El Paso County Planning and Community Development Department for a Special Use Permit for the additional principal use of a Recreation Camp (file #AL269)

Prepared by Stephen J. Spaulding, Consulting Forester, July 31, 2026

SITE DEVELOPMENT PLAN

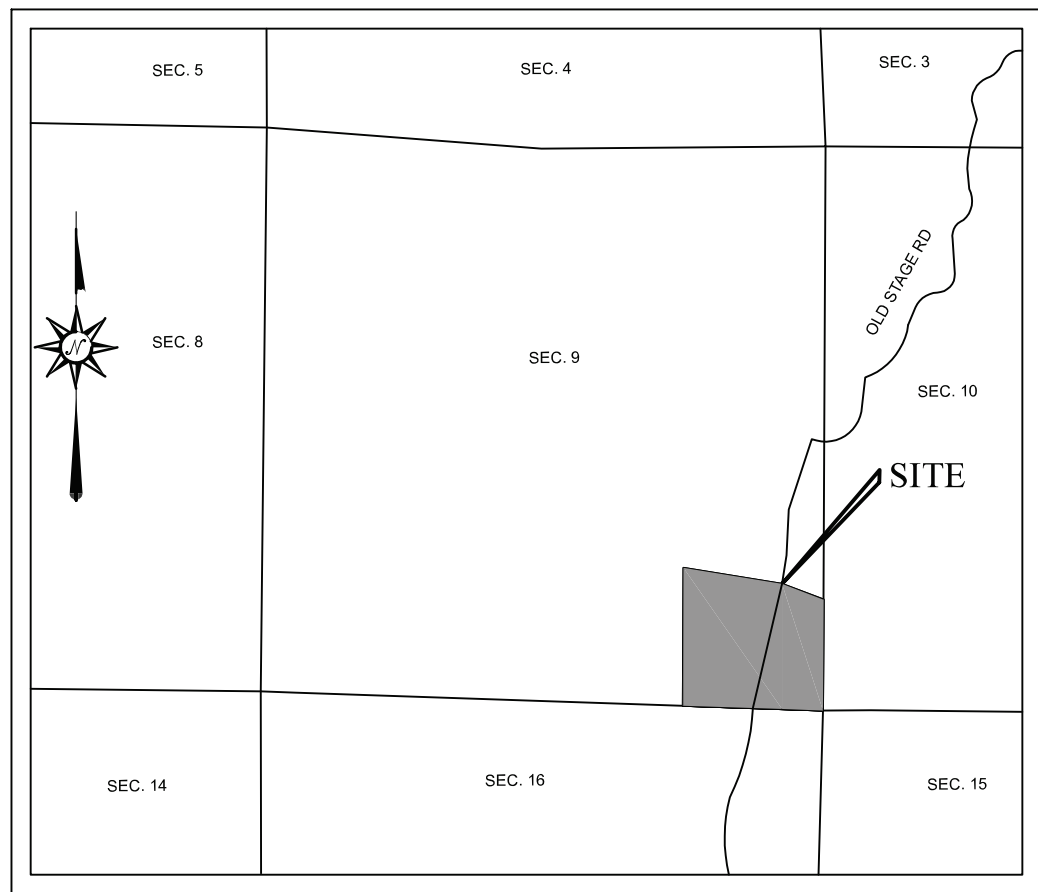
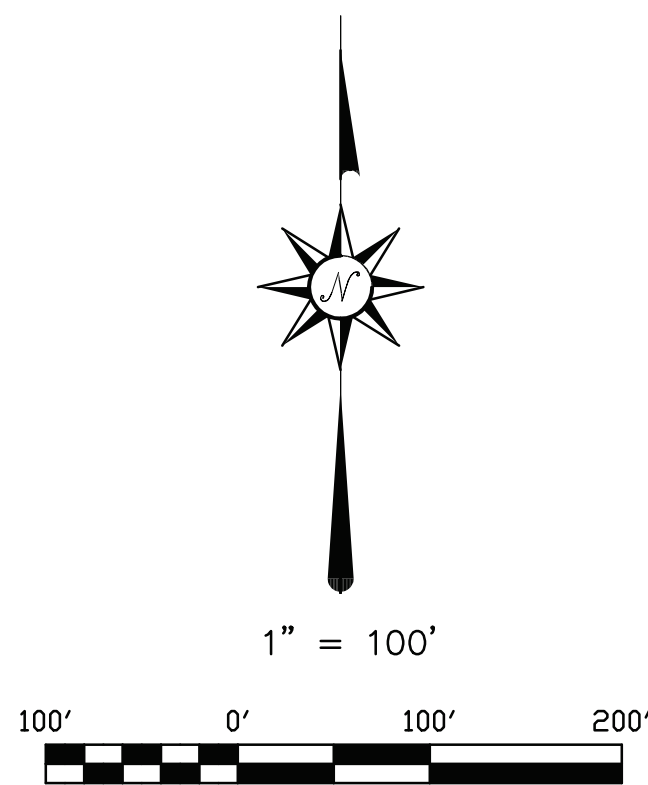
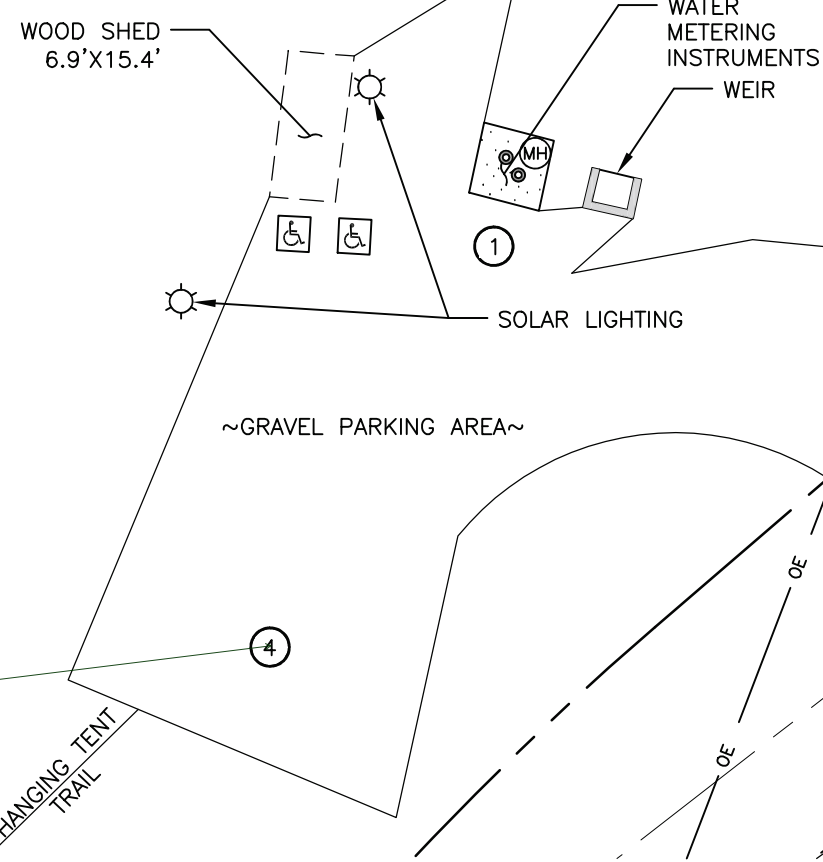
show on site plan

show on site plan

I want to point out how proposed parking in the ROW is not allowed, and could also be a fire hazard for emergency access. So, this will need to be addressed on Site Plan, letter of intent, and waiver request.

show on site plan for structures >200 sq ft

This all needs to be reflected on the site plan
